April 15, 2015

**Subject: 16 Middle Street
Final Level III Site Plan and Subdivision Application
Letter of Response #3**

SHEET TITLE
GRADING & DRAINAGE PLAN

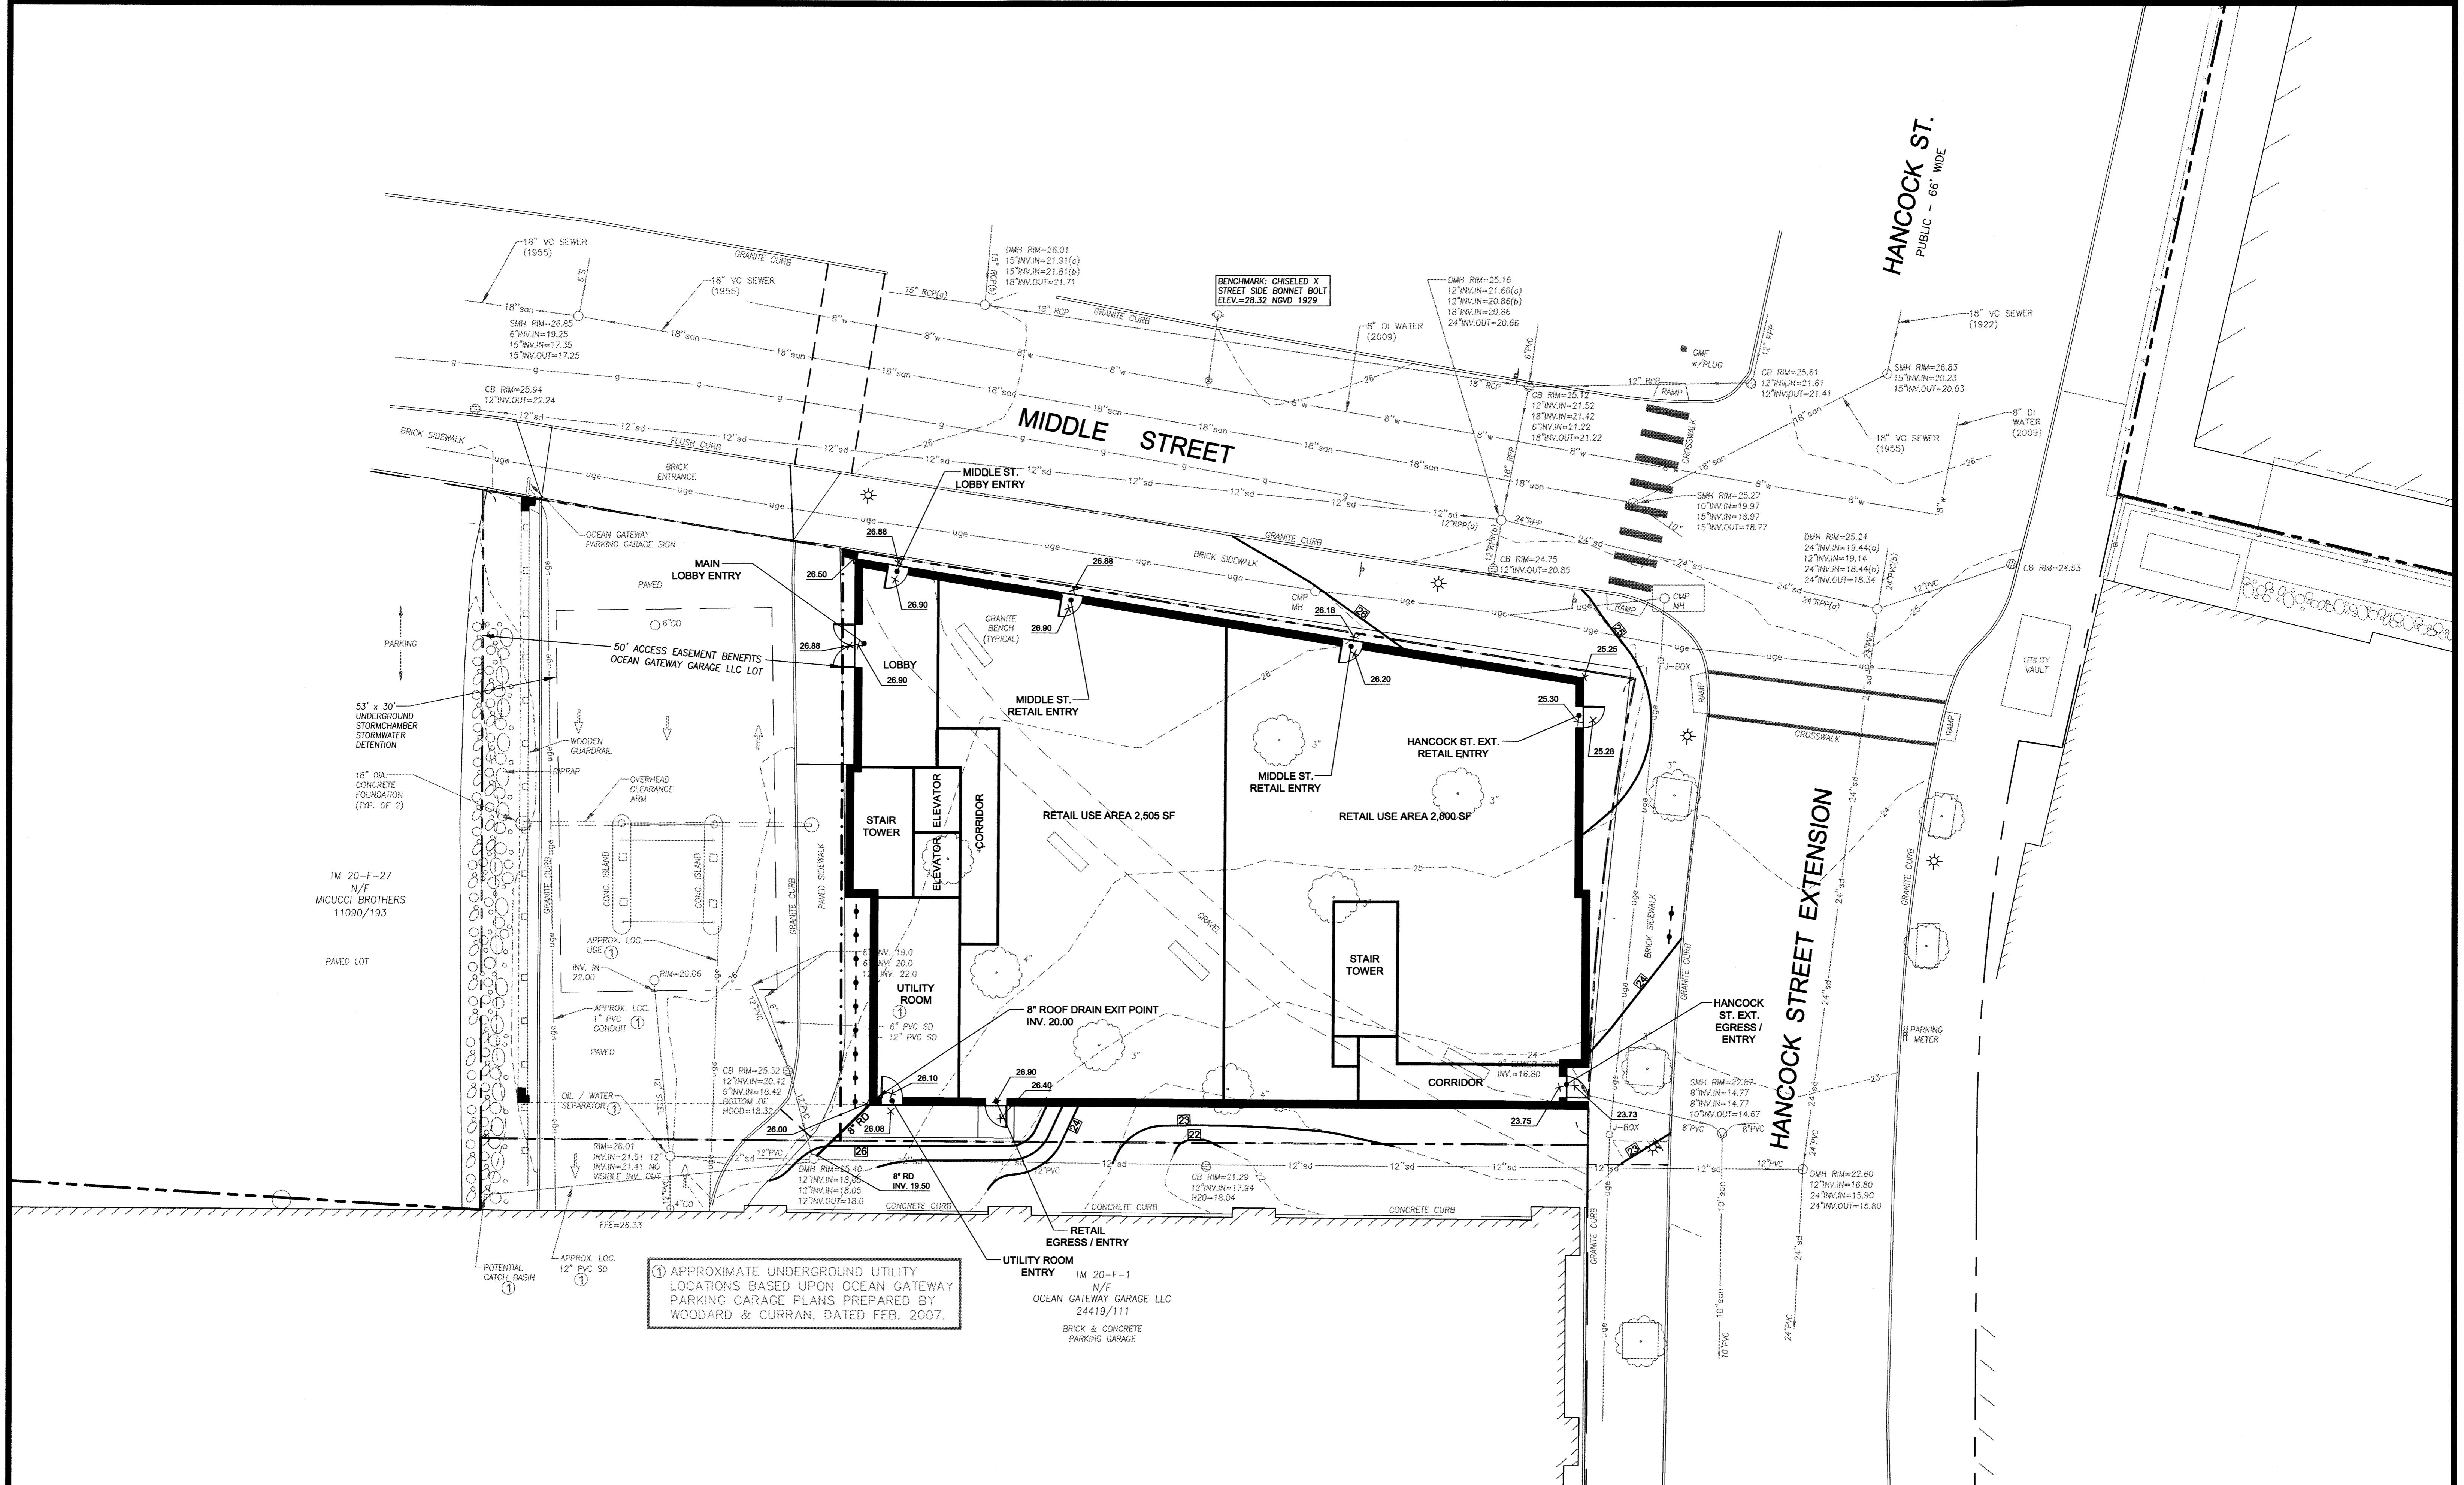
- a) *Basic Standards: The Applicant has provided a plan, notes, and details to address erosion and sediment control requirements, inspection and maintenance requirements, and good housekeeping practices in general accordance with Appendix A, B, & C of MaineDEP Chapter 500; however, a detail and proposed location should be provided for a stabilized construction entrance.*

A stabilized construction entrance has been added to the Grading, Drainage & Erosion Control Plan on Sheet C-4.0 and a detail has been added as Detail E on Sheet C-6.2.

F BARRIER FREE RAMP DETAILS
N.T.S.

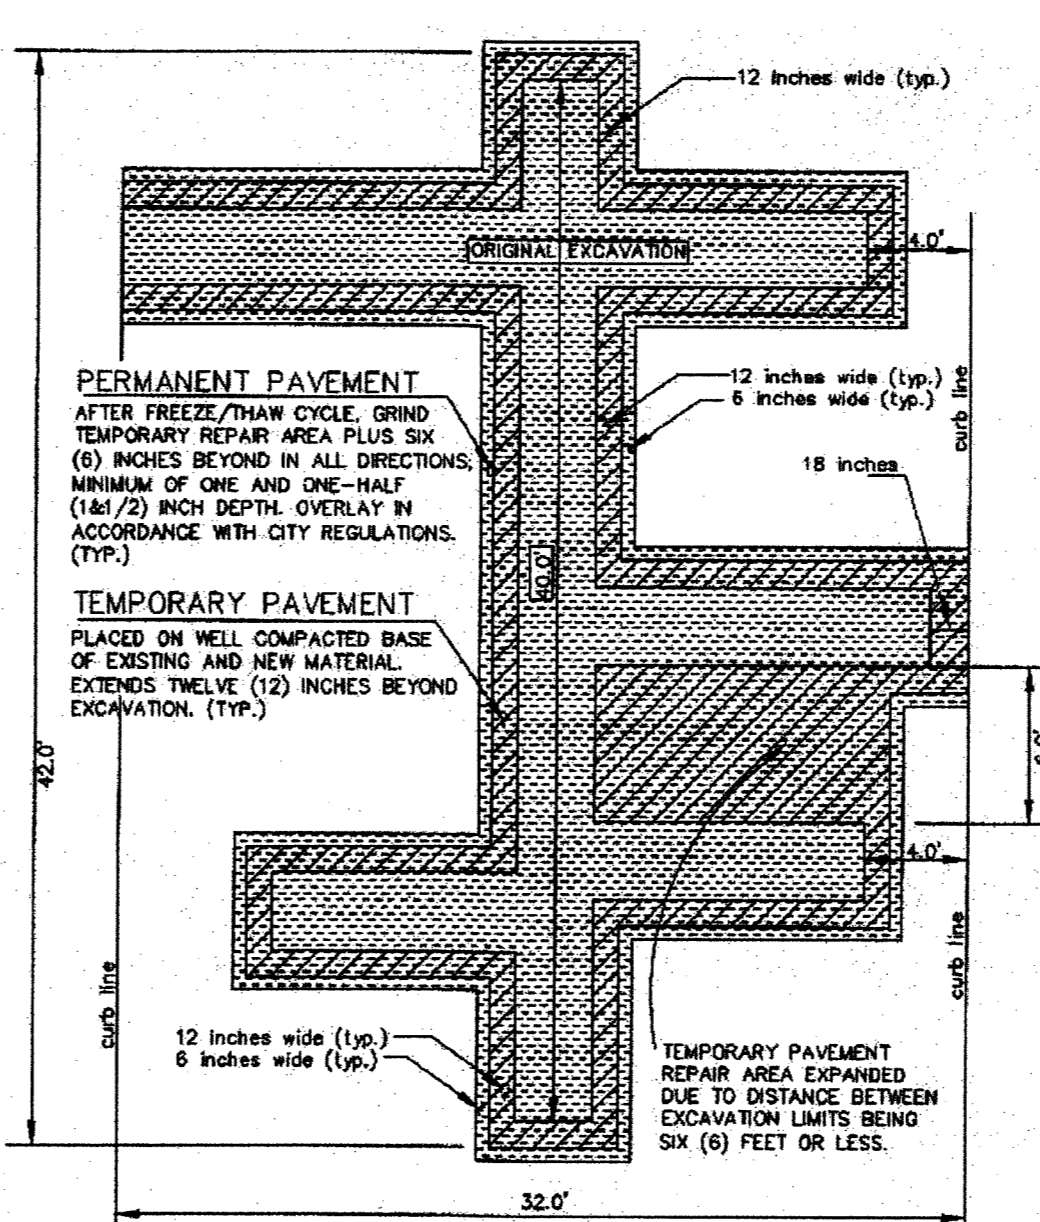
Both of the proposed cross walk ramps at the corner of Hancock and Middle Street shall meet current City of Portland standards and ADA standards. Cross walk marking in detail on Sheet C6.2 is incorrect. Please refer to Figure I-22 in the City's Technical Manual.

The two proposed sidewalk ramps are designed in accordance with current City of Portland and ADA standards. No crosswalk markings are proposed as part of this project.

SITE PLAN 1" = 10'-0"

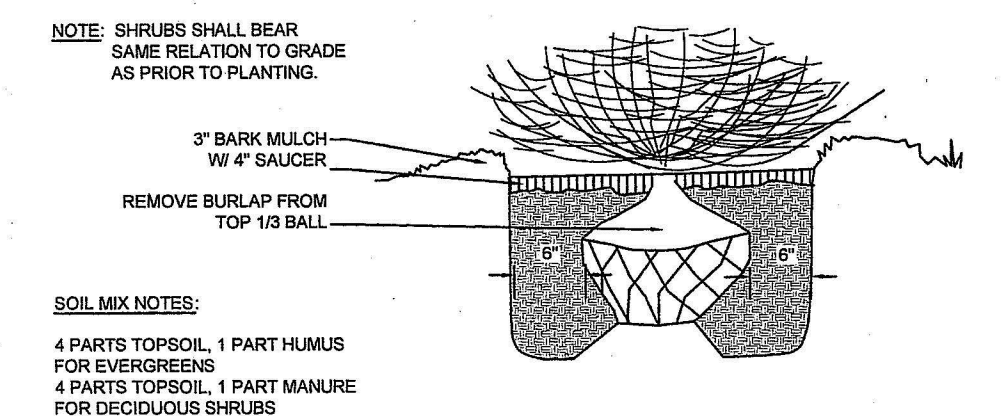
Relationship to Street – Building is set close to property line on all frontages. Staff requests that landscaping shown adjacent to retail façades be removed, especially on Middle Street. Although staff recognizes the intent was to ameliorate the inability to provide street trees in these locations, staff is not in support of placing landscaping between sidewalk and active ground floor facades. A wider sidewalk and easy access to the ground floor uses are preferred. City Arborist is amenable to removing the proposed landscaping.

The landscaping adjacent to the retail façade on Middle Street has been removed on the revised project drawings.
